ENG-PUDSP21010-R2-PUDSP.pdf Markup Summary

Subject: Image
Page Index: 1
Date: 1/18/2022 9:28:50 AM
Author: dsdparsons
Color: ■
Layer:
Space:
Page Label: [1] 1 COVER SHEET

C1.00

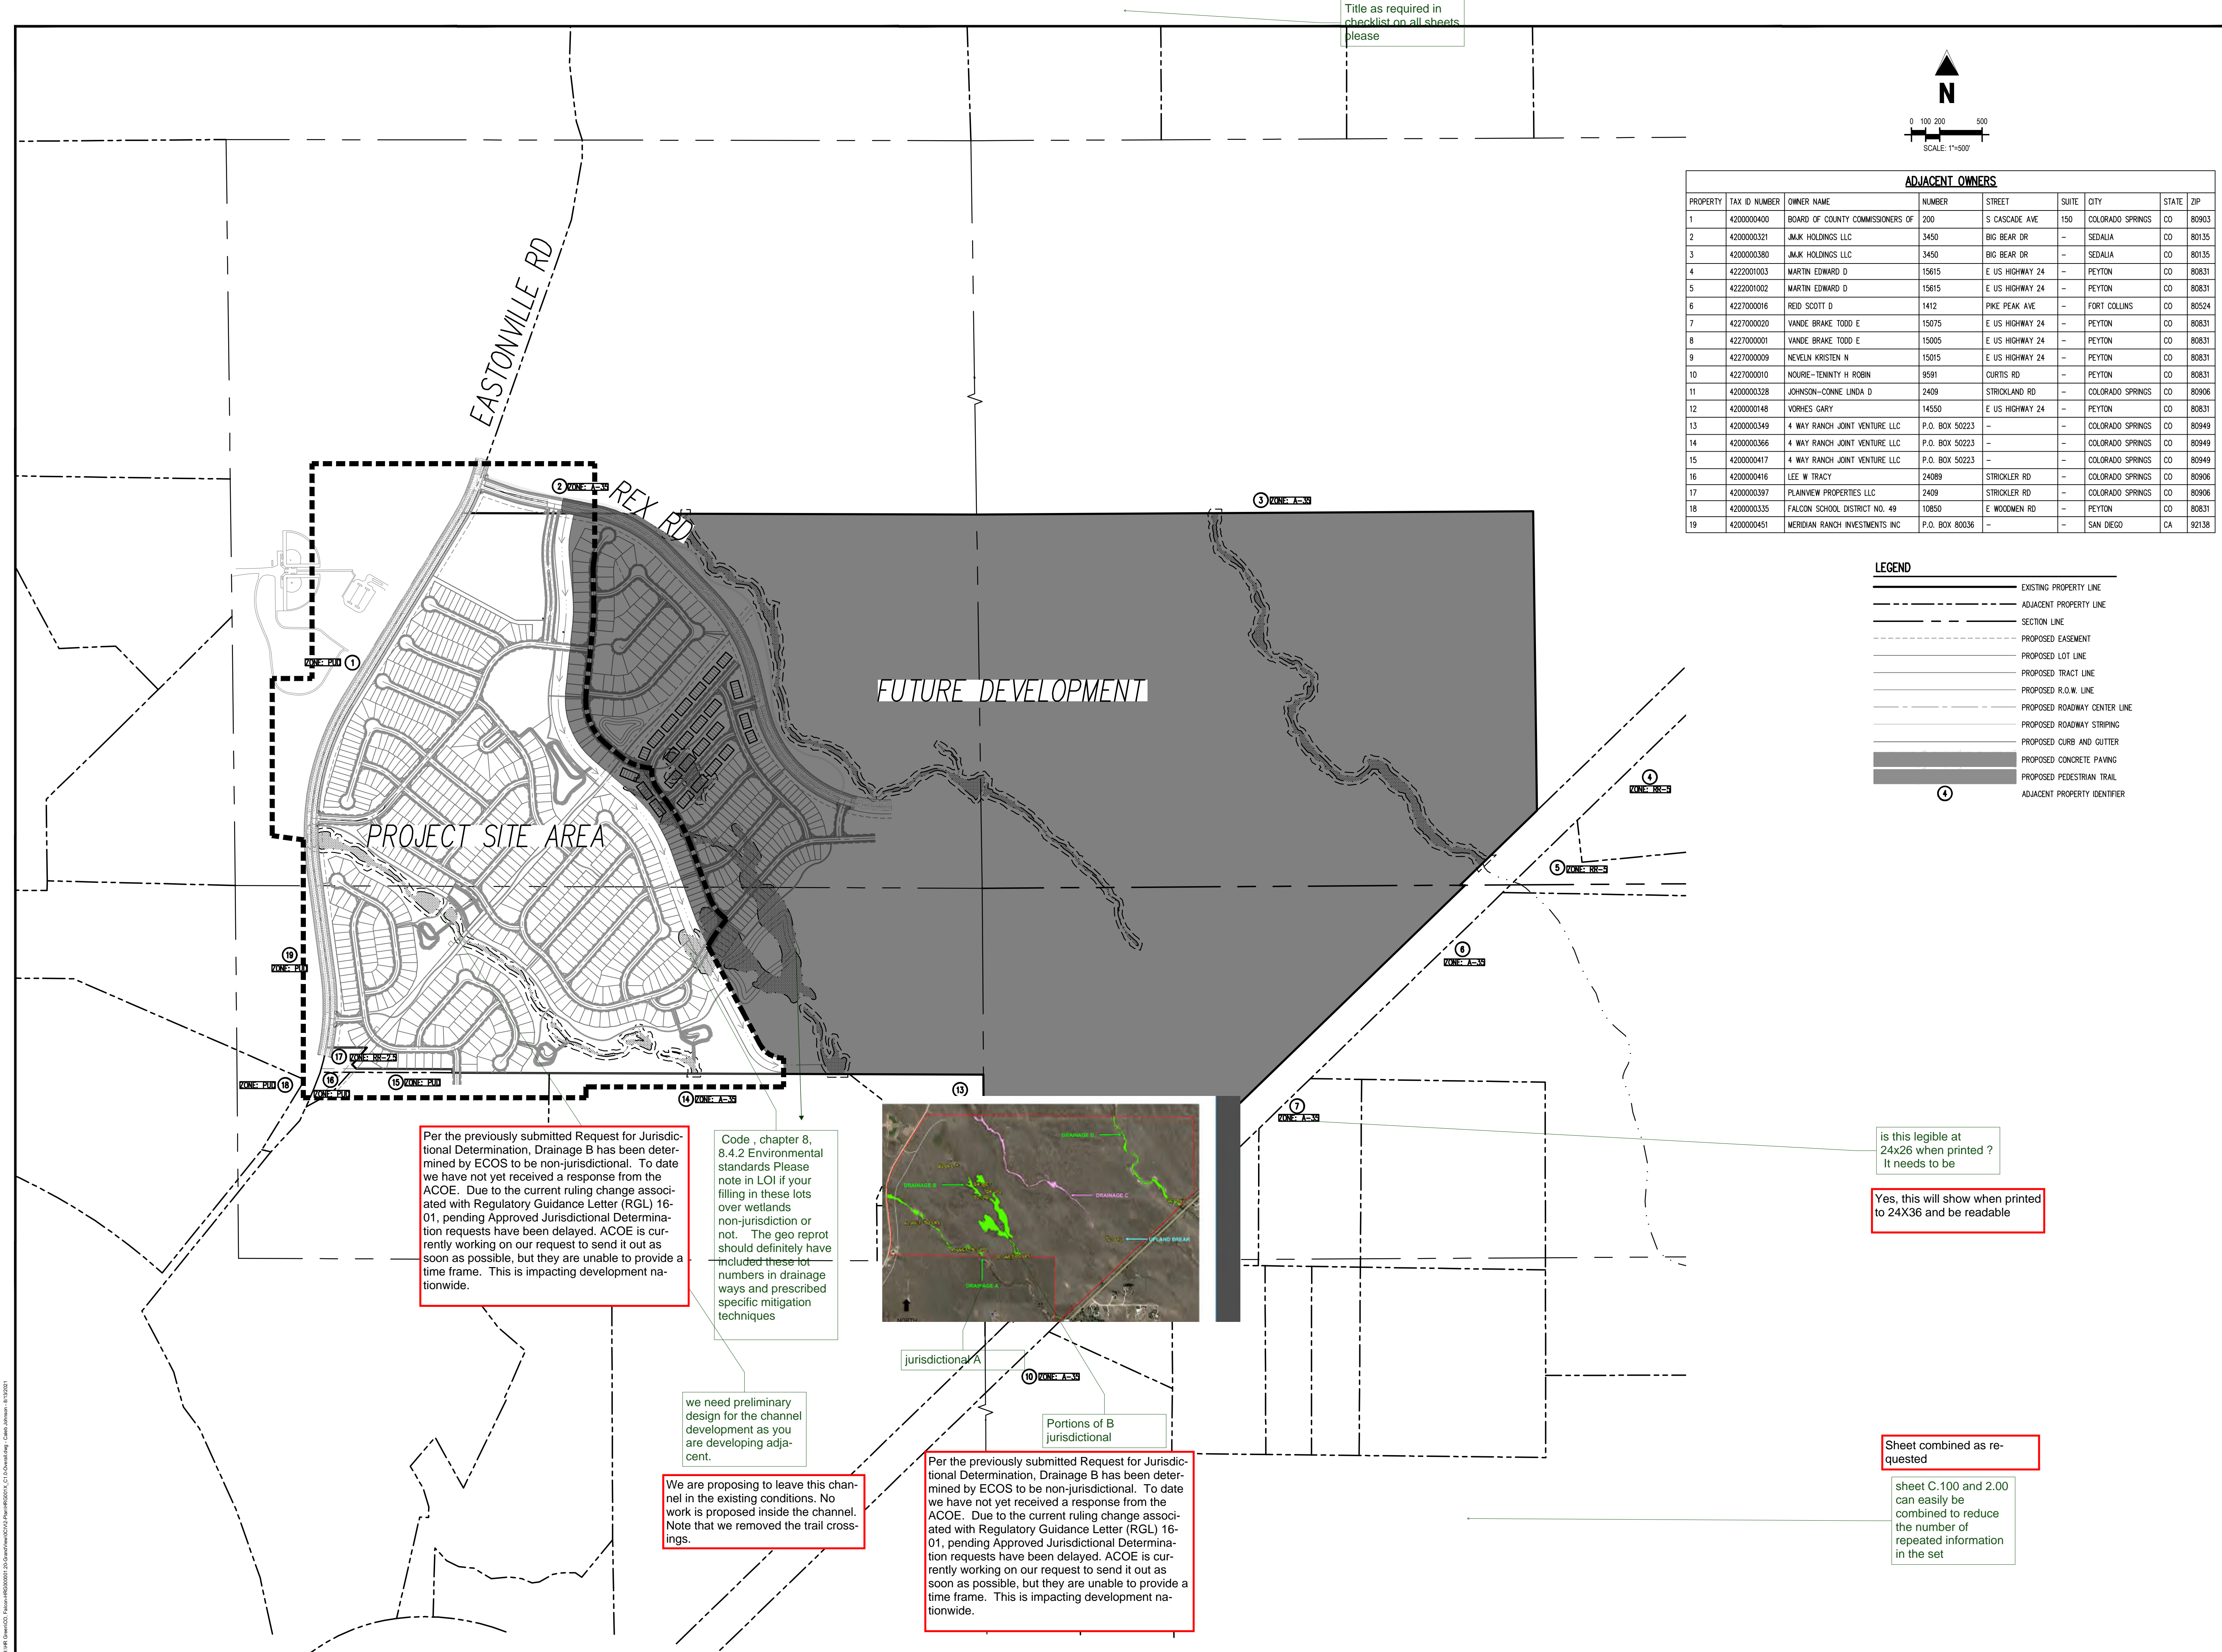
is this a trail?

BOUNDARY distance and bearings w/ dimensions add please (repeat comment)

label the trails (width and surface)

label the trails (width and surface)

Label as existing or future property line/ROW

Label proposed Eastonville centerline radii

Verify Eastonville ROW for curve design speeds per recent discussions

C2.00

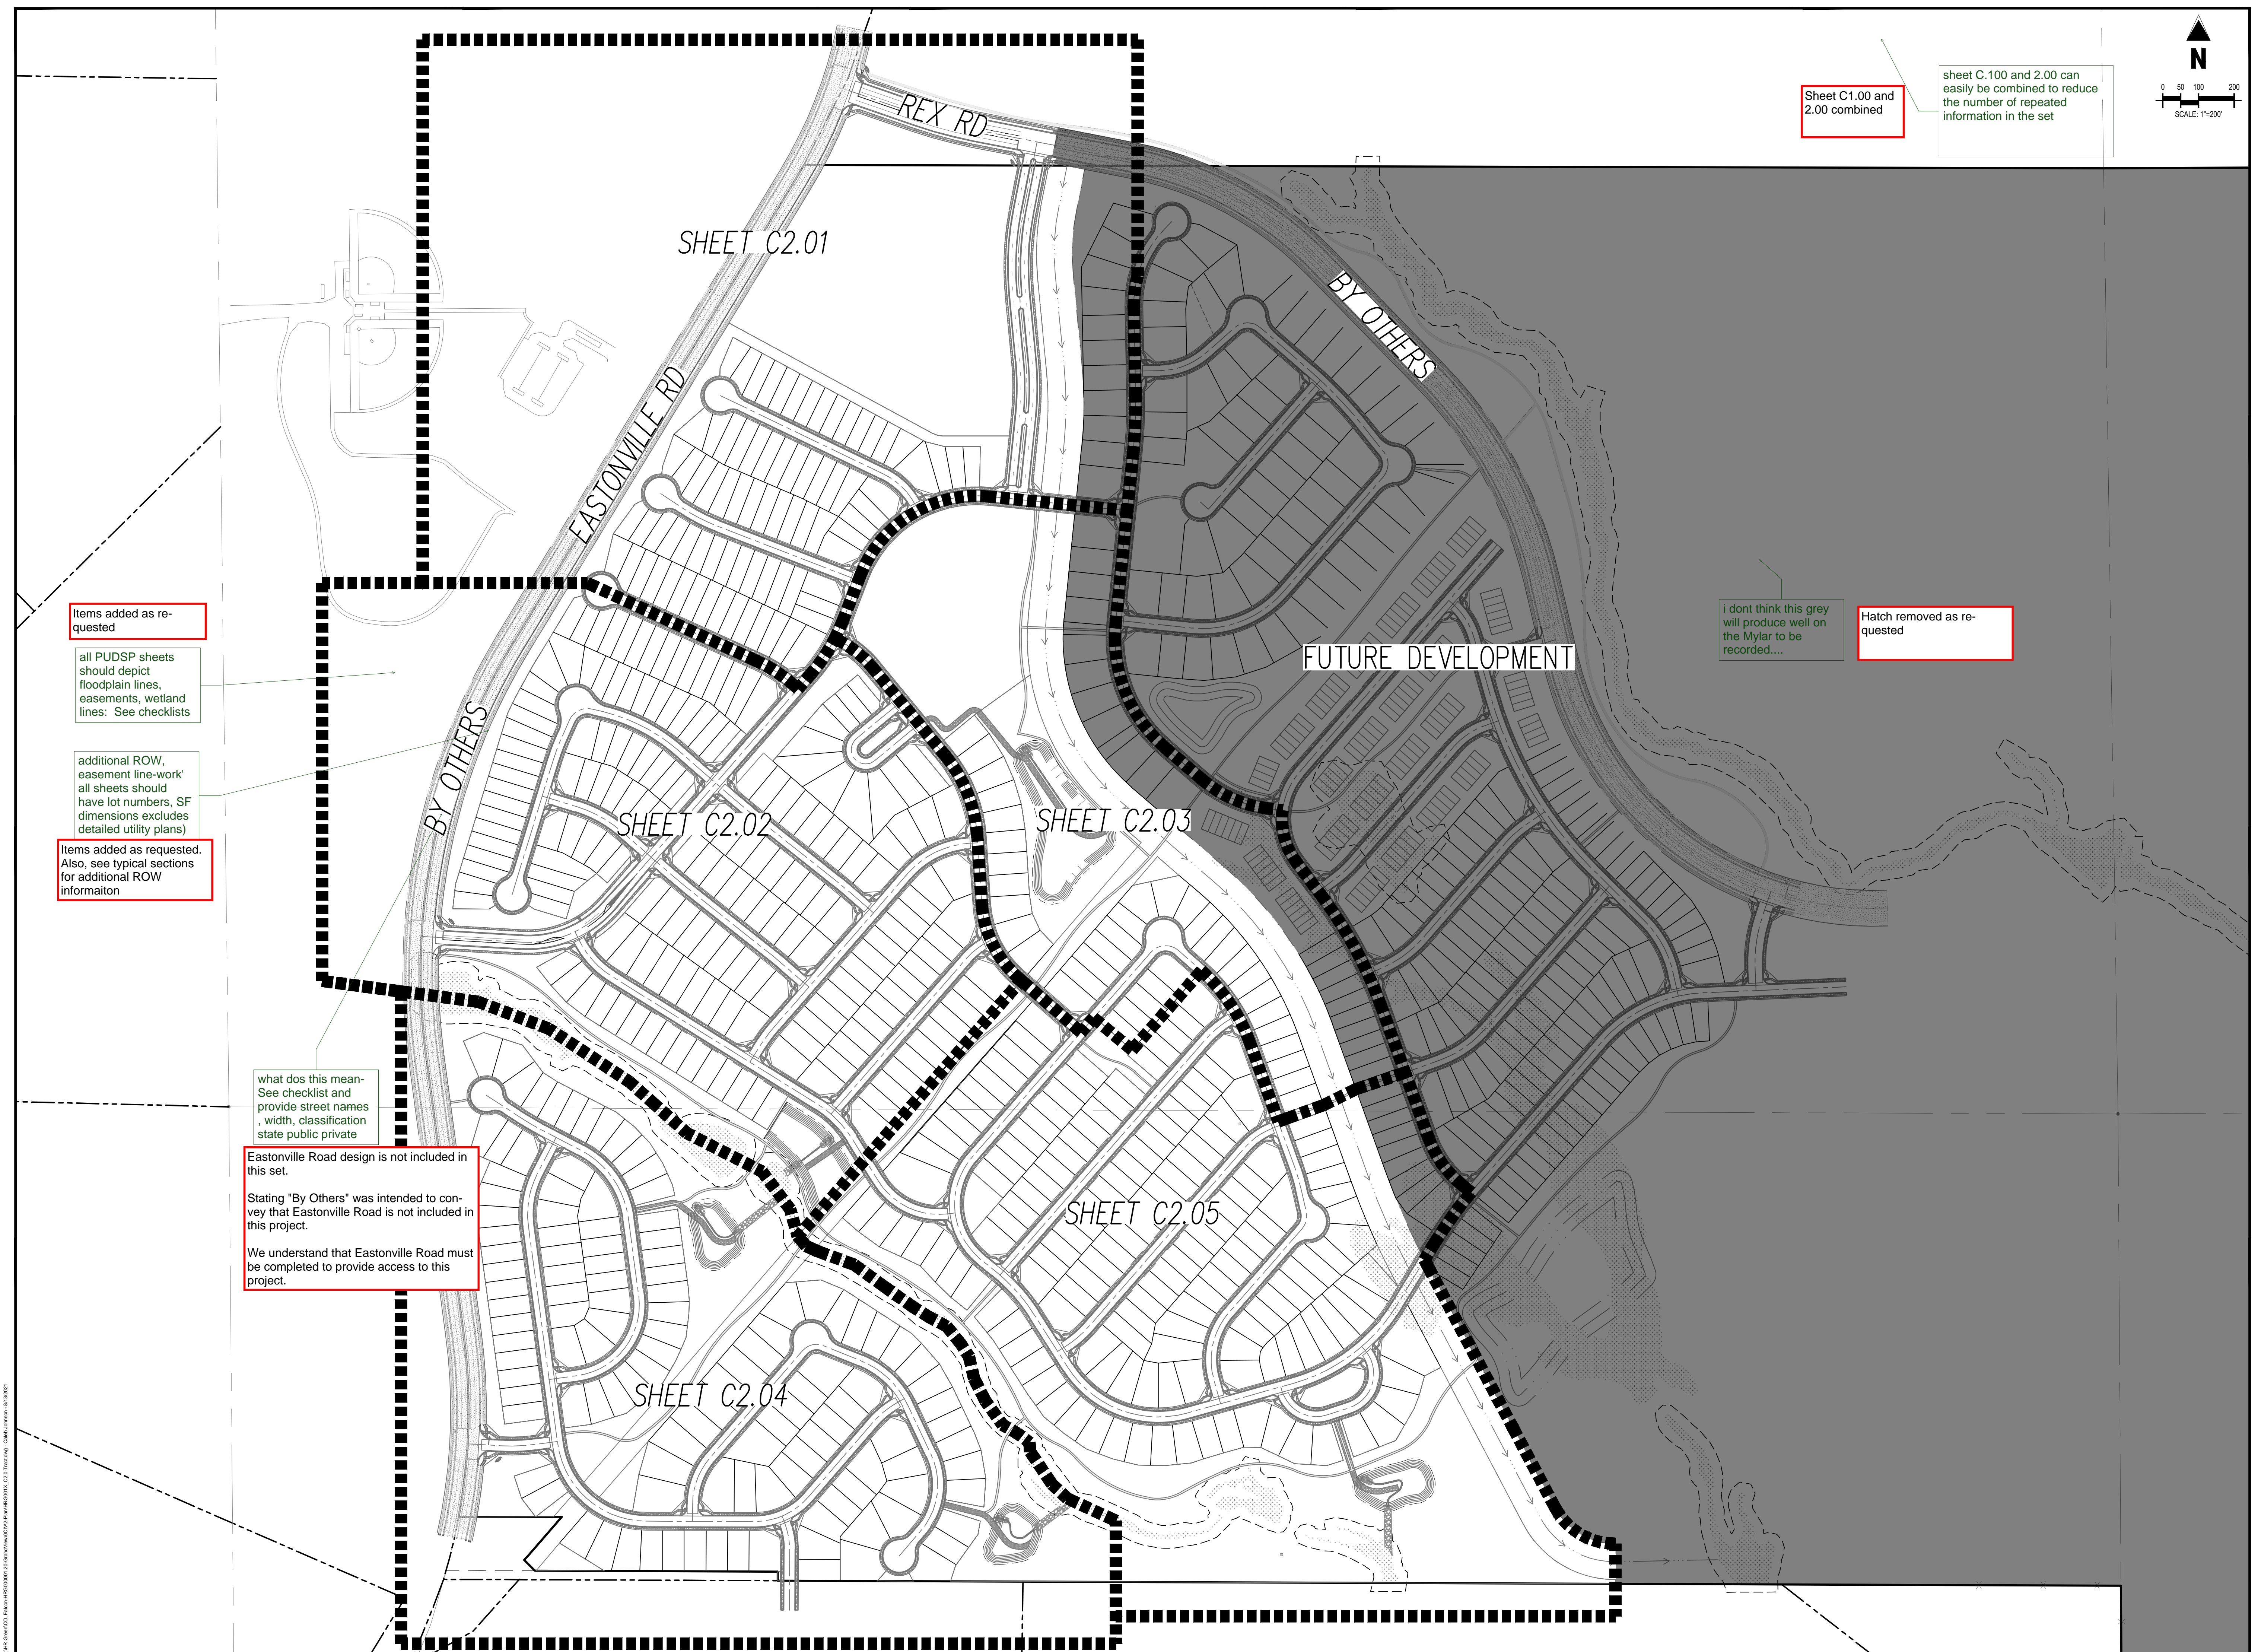
All lots shall depict square footage (acrage) and dimensions (angles are not required at prelim but you can leave them if its on that layer in AutoCad)

All lots shall depict square footage (acrage) and dimensions (angles are not required at prelim but you can leave them if its on that layer in AutoCad).

label the road names - this is required.

This is not approved access point; already there is a note that states no lots have access to Eastonville.

Please label these on map sheets its very hard to find these....

Adjust ROW

Label approximate centerline grades on all roads

Show conceptual improvements on this side (they can be grayed back). The curb returns and pedestrian ramps will need to be constructed with Grandview Reserve if not completed by others first.

this needs to be 24'
